From: Parish Clerk Billington and Langho Parish Council
<parishclerk@billingtonlanghopc.org>
Sent: 27 August 2026 07:04
To: Planning
Subject: Fwd: Consultation on planning application, 3/2026/0562, Blackburn Rovers
Academy Training Ground Brockhall Village Old Langho BB6 8BA
Attachments: 26 0562 Email Consultation.pdf

The application is for - Proposed floodlighting and new covered seating.

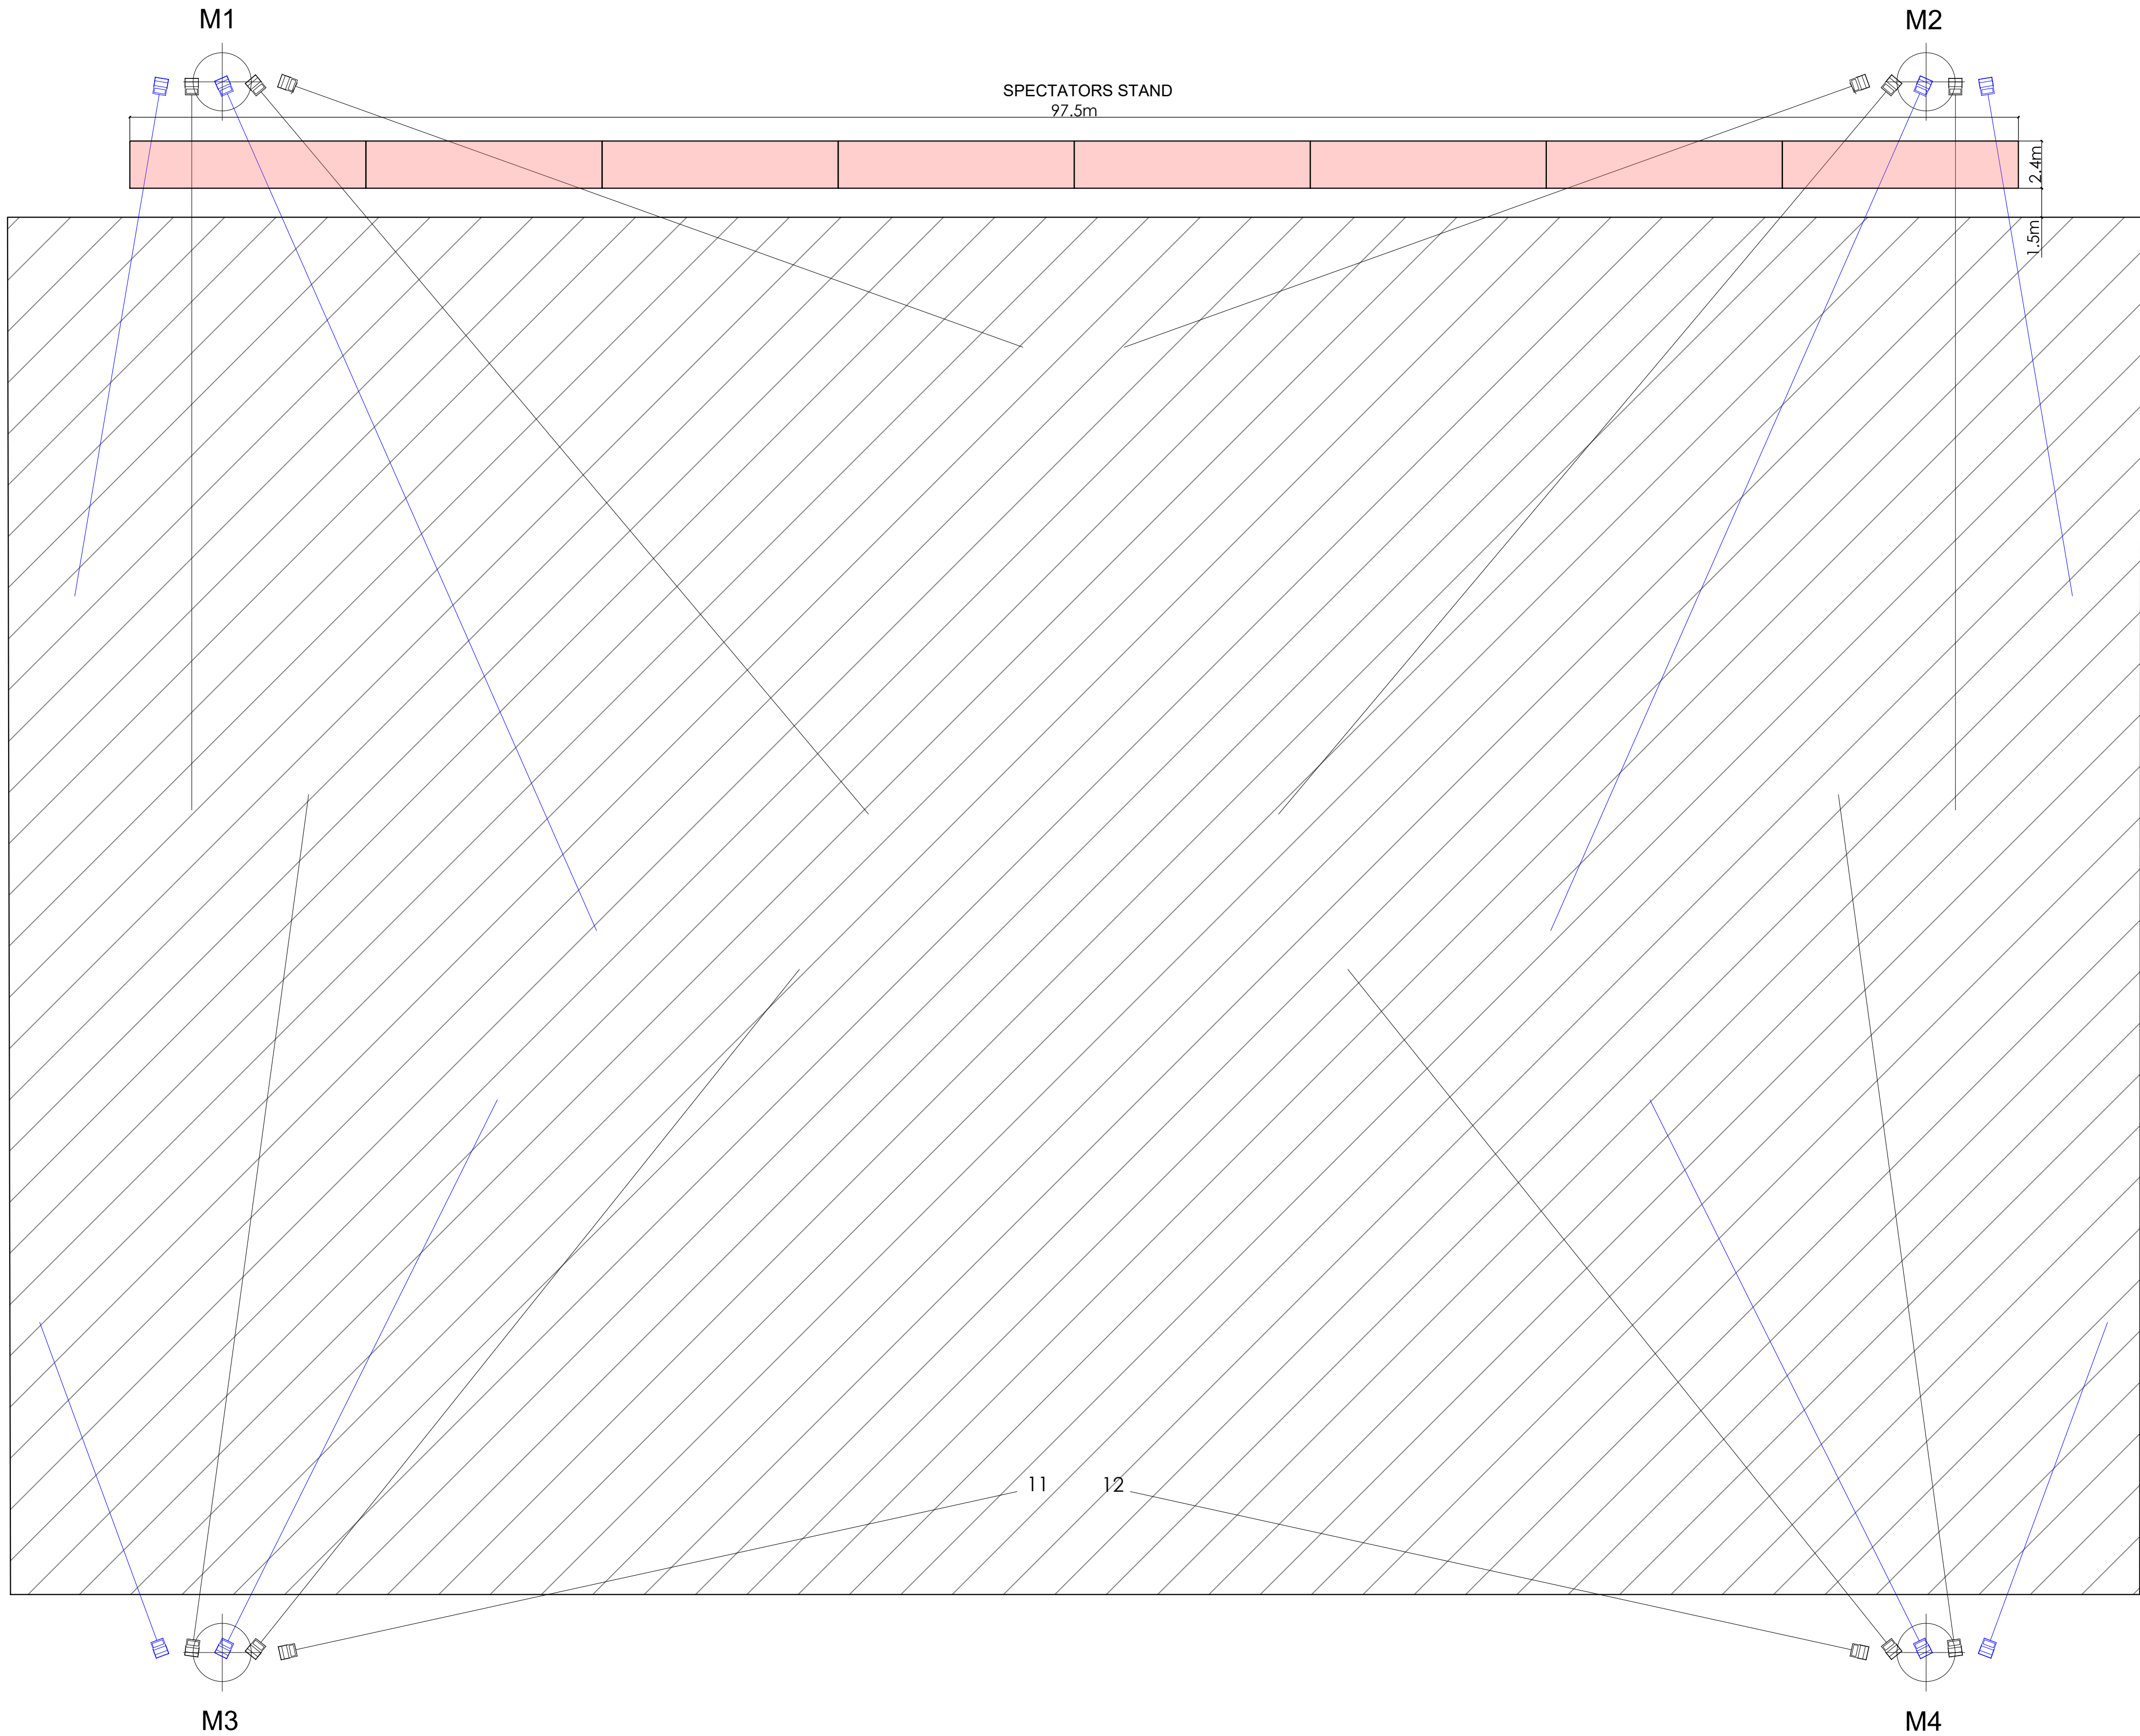
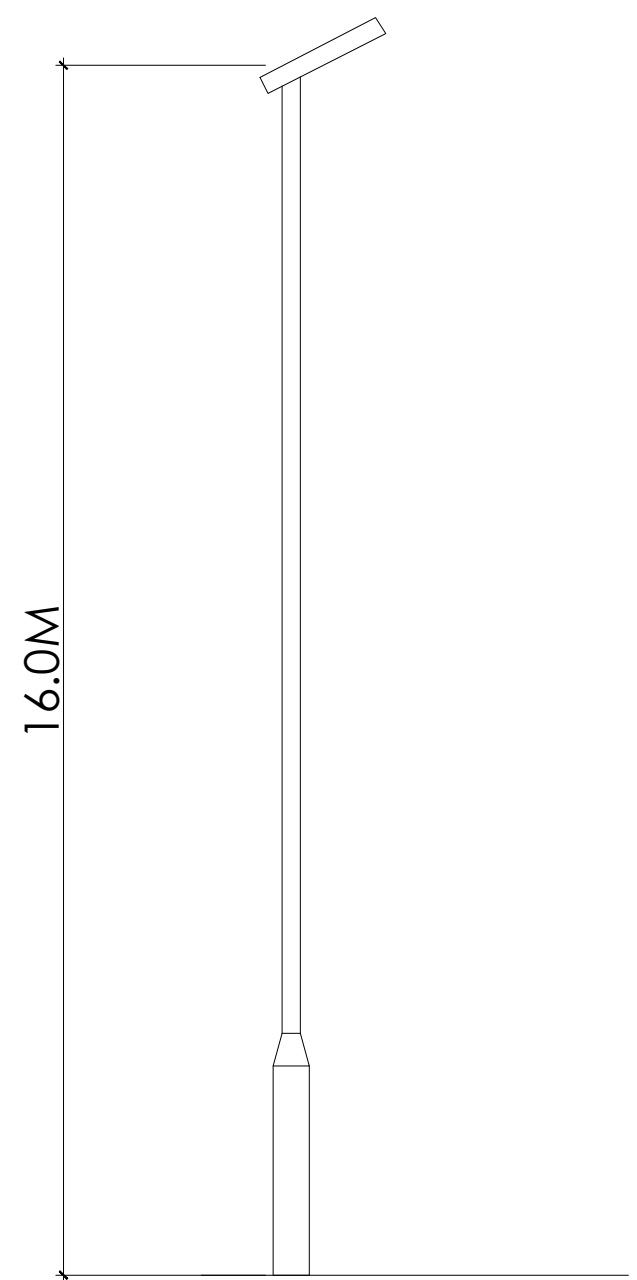
Good morning,
Further to the meeting of the parish council we have strong concerns regarding the potential light pollution.

It has been requested that appropriate shielding is used and that the light splay be monitored to ensure that those living nearby, particularly on Franklin Drive are not adversely affected by this new lighting.
